DRB Application No.: 08DRB-70465

Project Name: FRANCIS

ITEM # 17

**RE: Lots A & B, Francis Subdivision, plus Tract 238C2A,
MRGCD Map #38**

**PLAT OF
 LOTS A-1 AND B-1
 FRANCES SUBDIVISION**

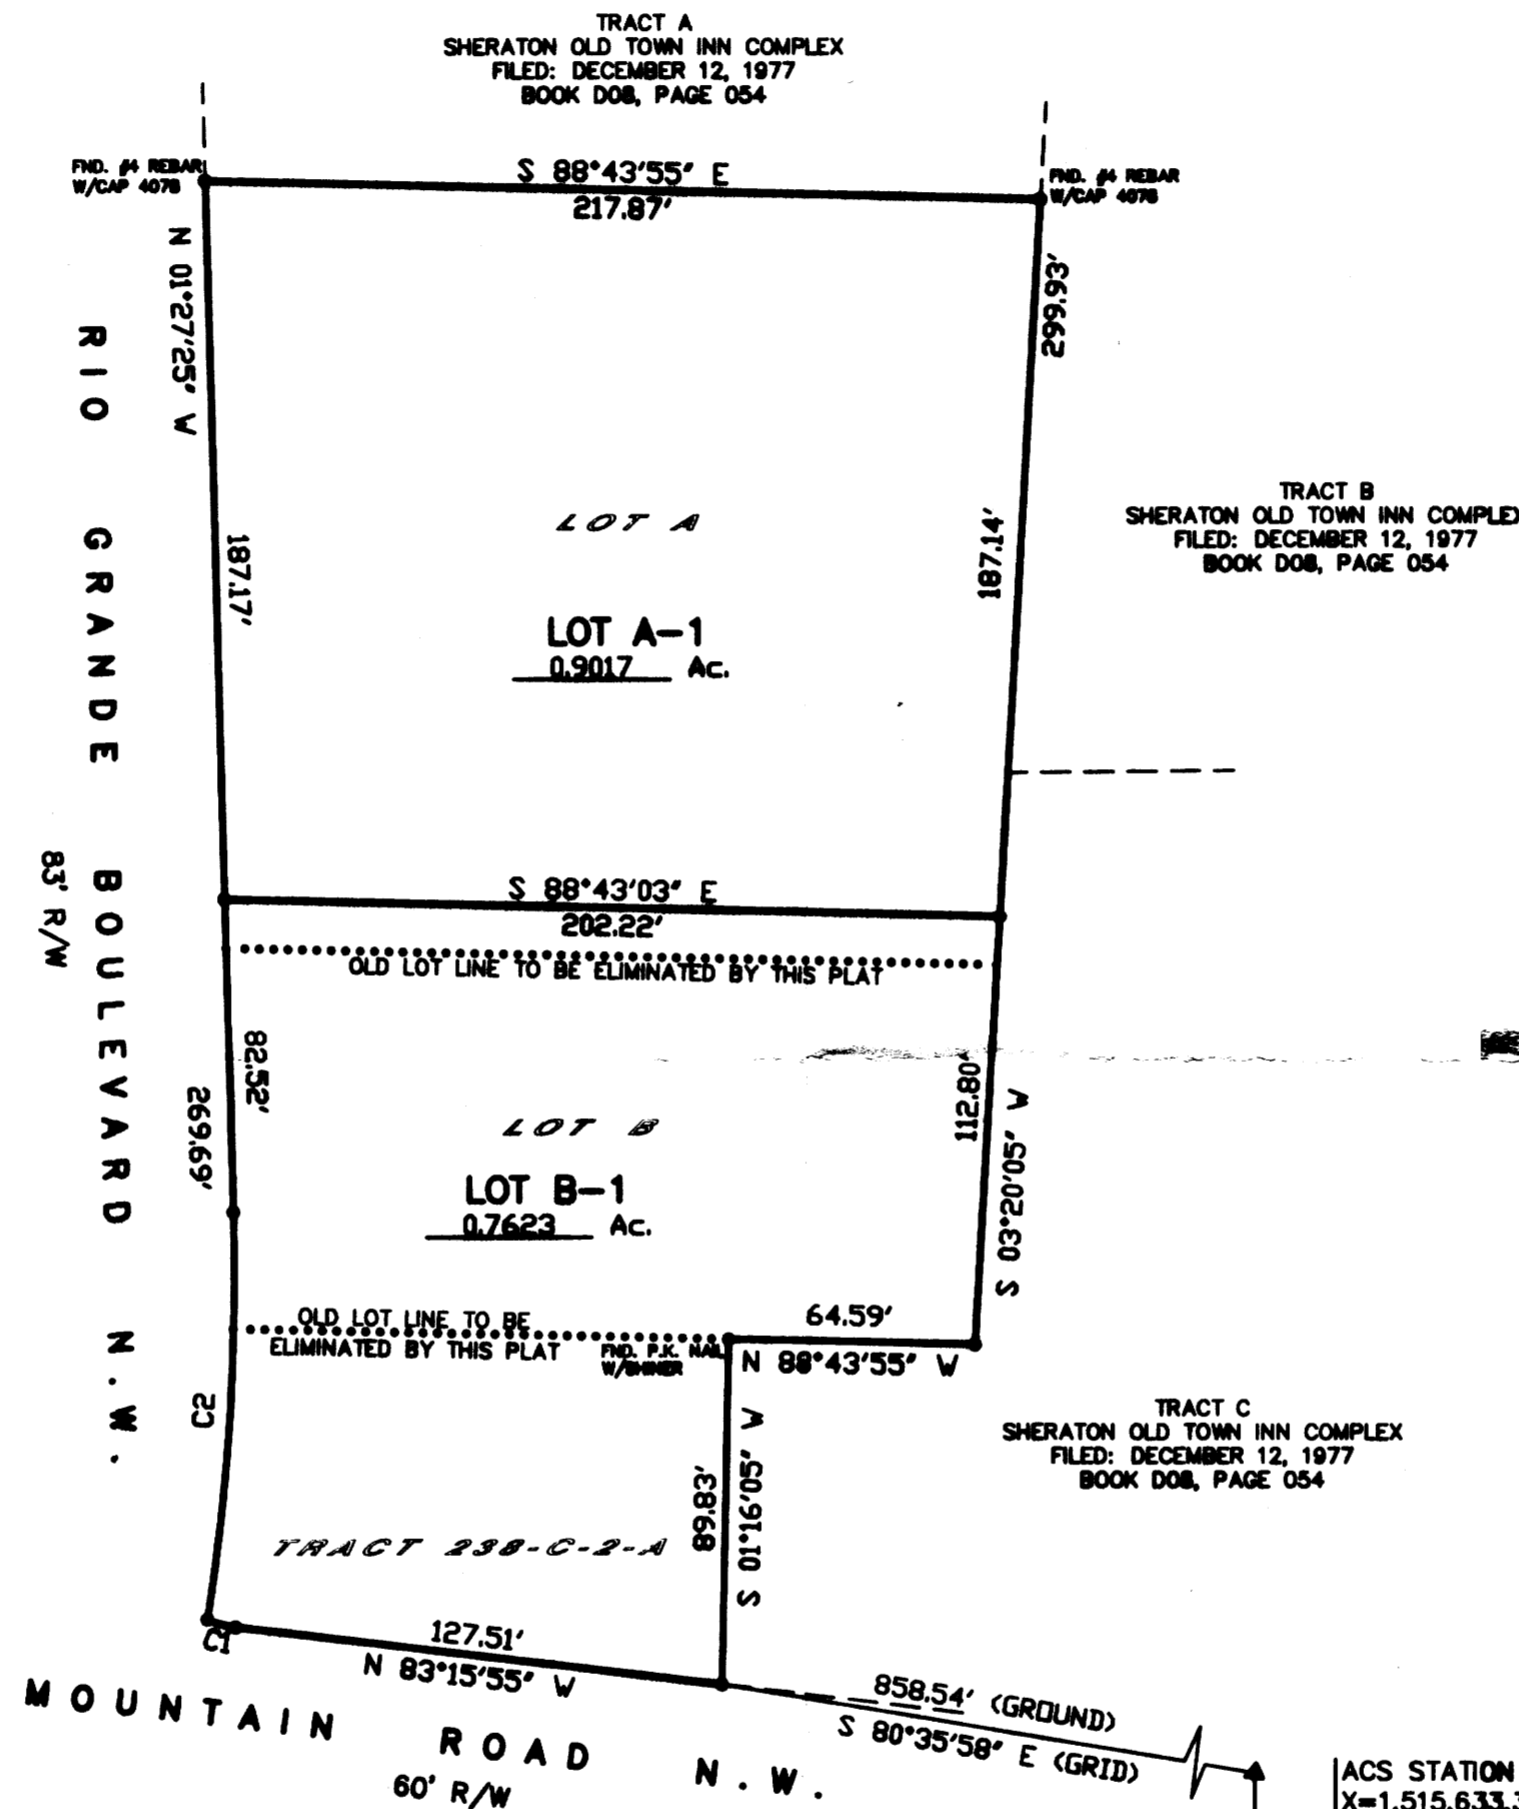
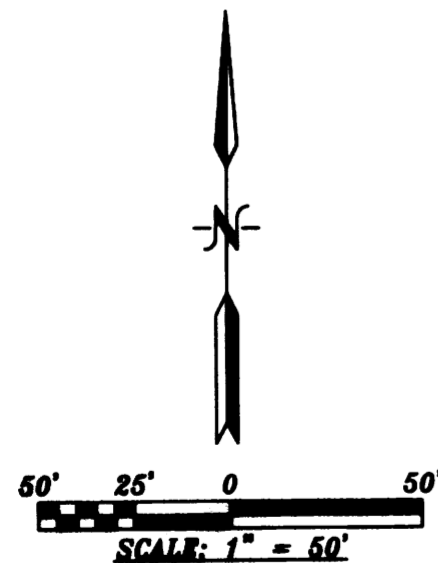
TRANSPORTATION: comments - dimensioned exhibit

CITY ENGINEER / AMAFCA: - reciprocal easements

It appears reciprocal easements for access, parking and drainage will be needed between the 'new lots' – please reference any existing such easements with adjoining lots.
